WEST SUSSEX COUNTY COUNCIL CONSULTATION

TO:	Arun District Council FAO: Anita Gardner
FROM:	WSCC - Highways Authority
DATE:	5 May 2021
LOCATION:	Land South Of The Littlehampton Academy Fitzalan Road Littlehampton BN17 6ED
SUBJECT:	LU/116/21/PL Erection of 112 No. residential units with access from Fitzalan Road, open space, hard and soft landscaping works, internal roads/footways, car and cycle parking, substation, bin store and associated engineering and infrastructure works. This site is in CIL Zone 4 & is CIL Liable as new dwellings.
DATE OF SITE VISIT:	n/a
RECOMMENDATION:	More Information
S106 CONTRIBUTION TOTAL:	n/a

Figure 7.1 Travel Plan Timetable

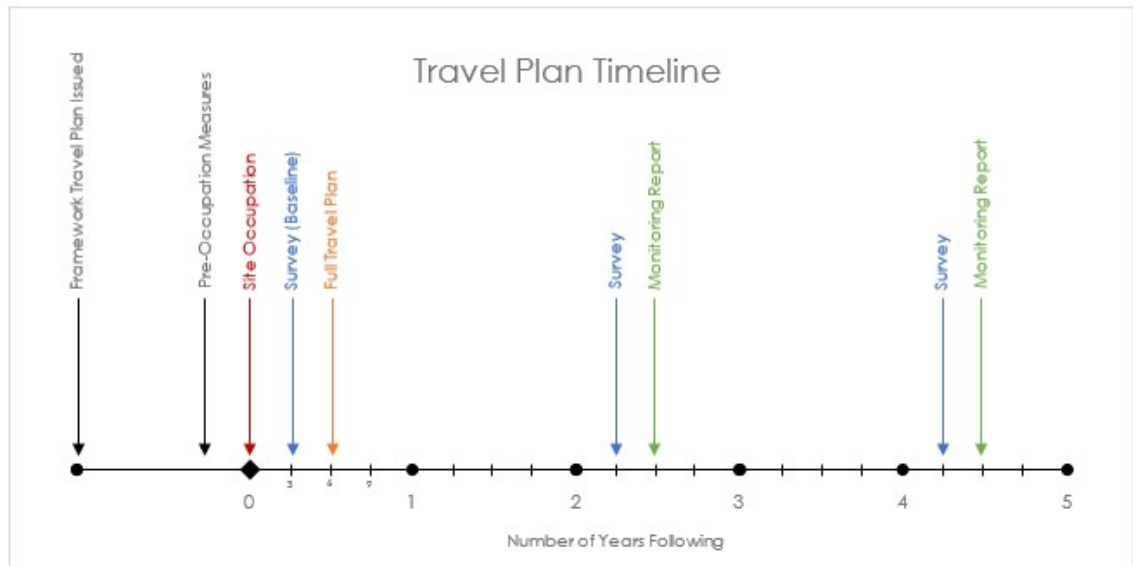
- It would be helpful to understand the potential build out duration. This is raised in respects of the commissioning of initial baseline travel monitoring, which is indicated to be commenced 6 months after full occupation. This could result in the baseline surveys being undertaken sometime after the first dwelling has been occupied. It may be more

appropriate to consider undertaking the baseline surveys once the site is 75% occupied.

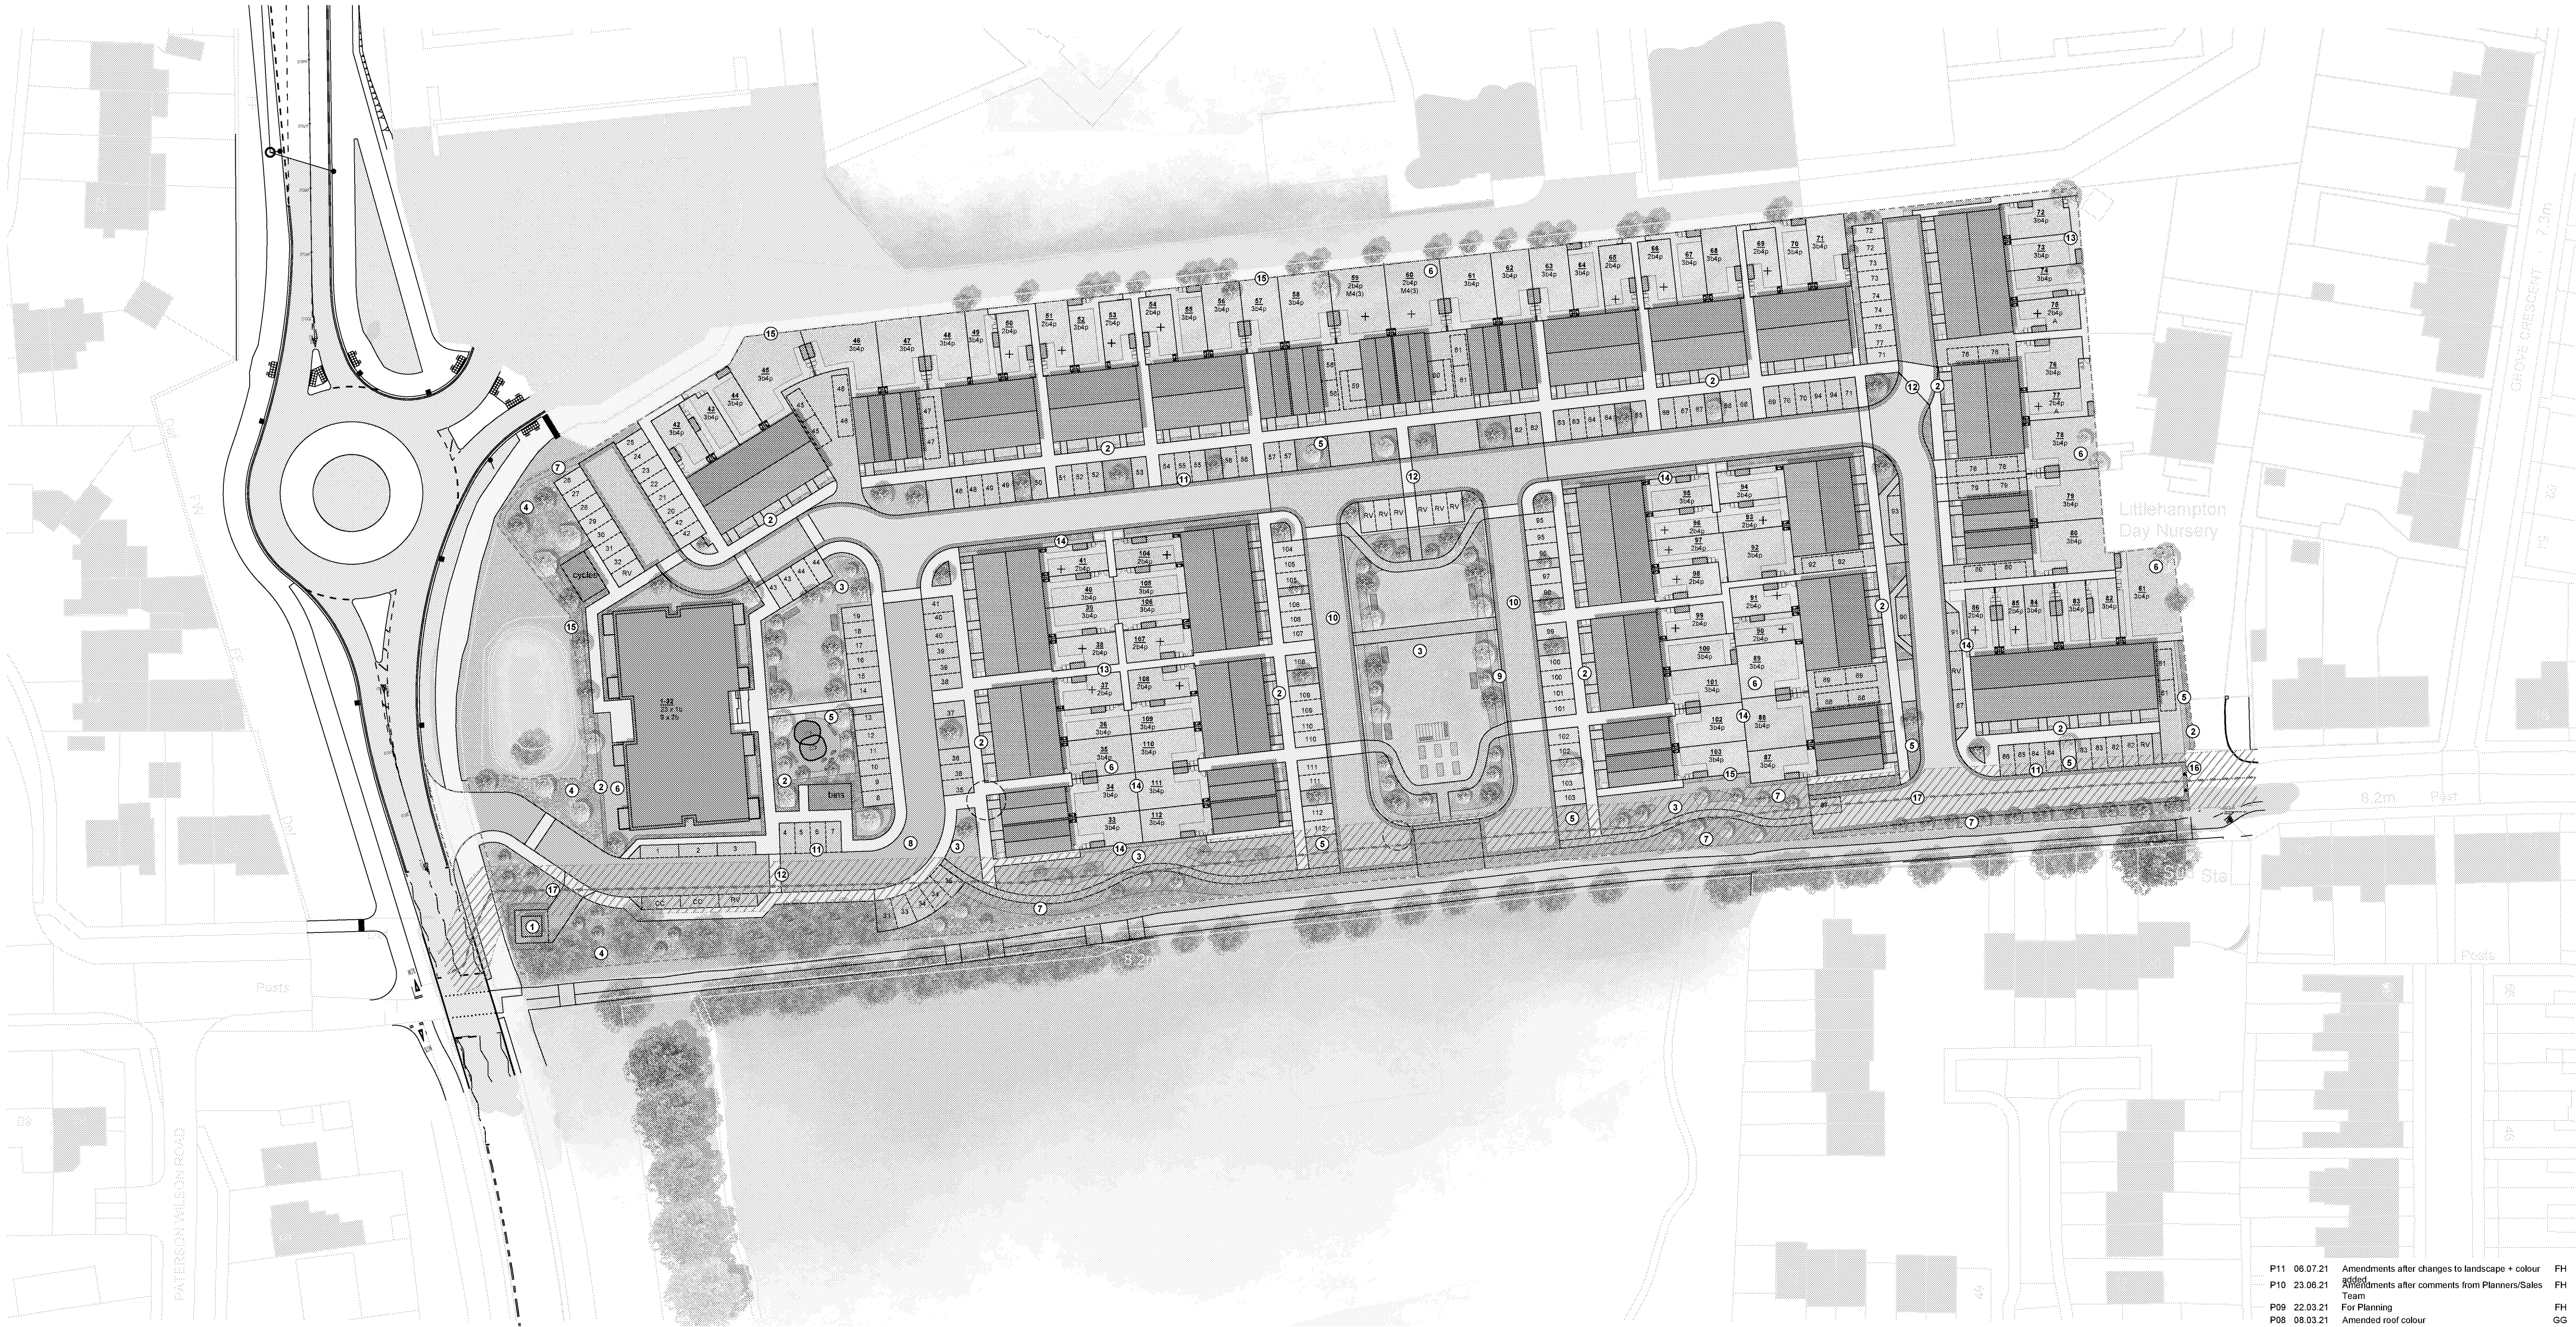
15. The only specific comment regarding the layout relates to specifics in terms of parking.
 - With those spaces running immediately adjacent to the carriageway edge, if the applicant's intention is to offer the roads for adoption but to allocate parking spaces to specific properties, a margin of at least 0.5 metre would be required between the carriageway edge and what will then have to be private parking spaces (as allocated parking cannot be provided within the public highway). This margin would be required to enable WSCC to maintain the highway edge.

- With respects to the above point, it should be noted that if the spaces are to be allocated/private, the preference would be for the footway (which is likely to be adoptable) to run adjacent to the carriageway edge (which would also be adoptable). The issue with the layout as shown is that this introduces the potential for private car parking spaces to be sandwiched between the adopted footway and carriageway. Again, comments are made on the basis that the layout will be adopted, which may not be the case.

- Car club parking spaces are also indicated. From the correspondence, the car club operator is willing to operate a single vehicle from the site initially, increasing to two vehicles if demand justifies it. It's recommended that only a single car club space is initially marked out. If the roads are to be offered for adoption, a traffic regulation order would be required to reserve the respective parking space for use the car club use.

16. The applicant has reviewed the overall number of parking spaces against the Arun DC parking standards. Based on adopted standards 188 car parking spaces would be required. The site provides 178. Justification for the reduced level of parking includes the sustainable location promoting less car dependency and inclusion of a number of unallocated (39 plus 10 intended for visitors), and therefore flexible use parking spaces. It is understood from the correspondence included in the TA, that the overall approach to parking has been agreed with Arun DC officers.
